W400-38F02- Letter.doc

**RE: 7 Railway St, Chatswood – Changes to Street Planting**

WINDTECH Consultants Pty Ltd

Landscape Master Plan

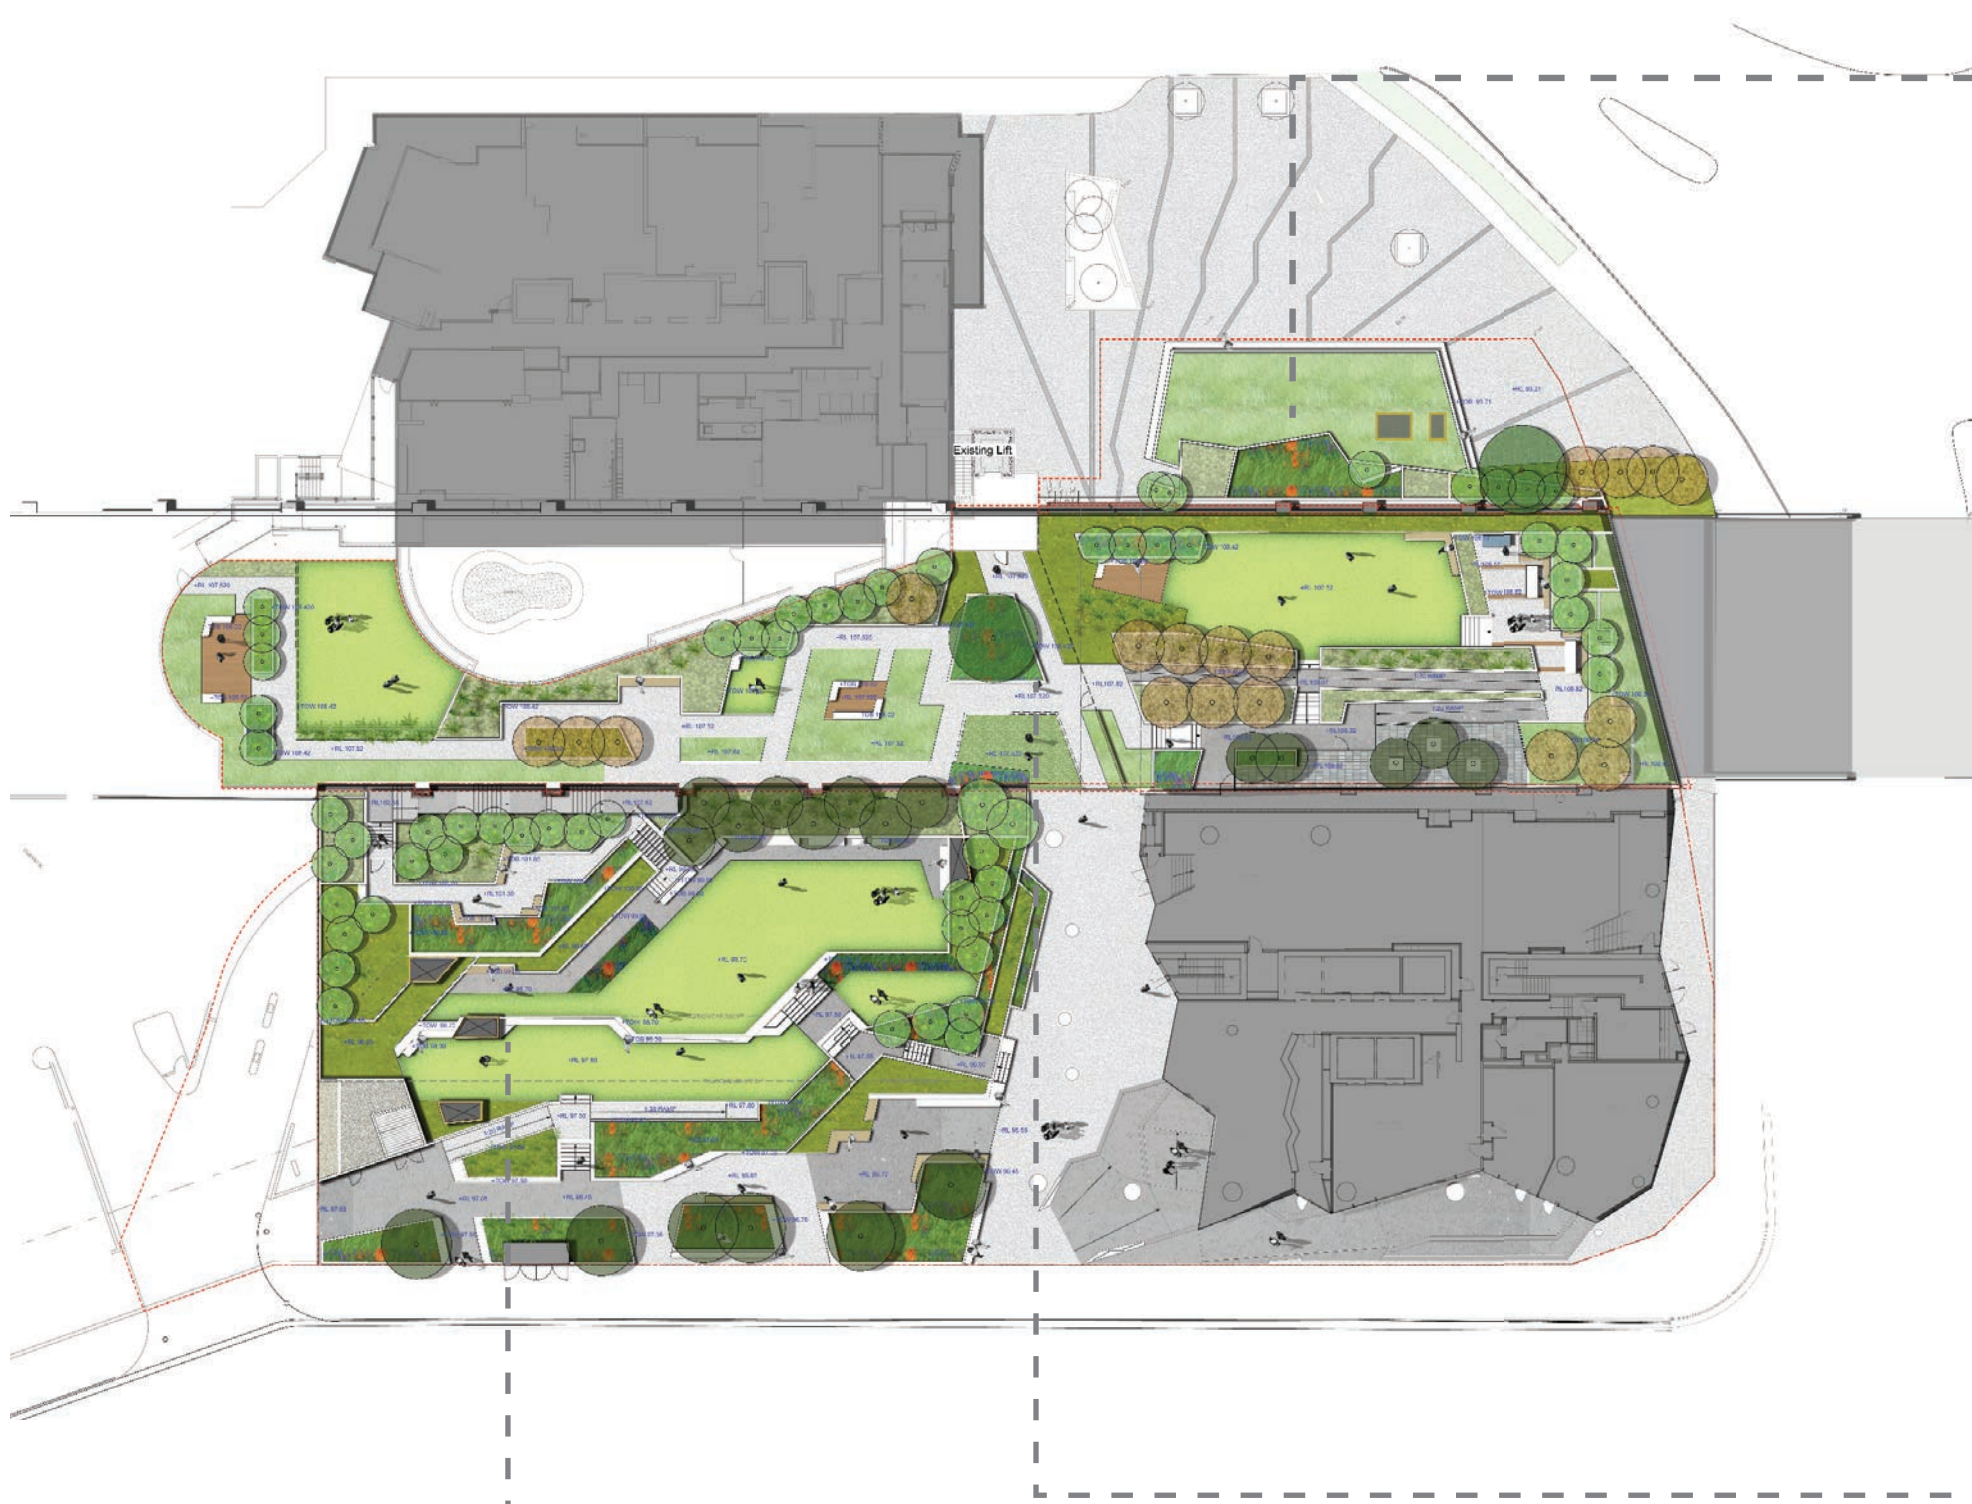
This letter is to clarify the reason for the deletion of the street trees at the corner of Railway and Help Streets from our list of recommended treatments.

Our original report had recommended the provision of 2 trees near the corner of Railway and Help Streets to address the slight exceedance of the comfortable walking criterion at that corner (represented by Point 20). It should be pointed out that this is an existing wind effect and is not exacerbated by the proposed development. In addition this slight exceedance is a very localised effect. The wind conditions at the study points Points 54 and 55, located either side of Point 20 indicate that wind conditions are within the comfortable walking criterion without the introduction of any planting.

In light of the existing wind conditions, the very marginal exceedance at Point 20 and the very localised nature of this wind effect, it was decided mitigation measures are not warranted for this area.
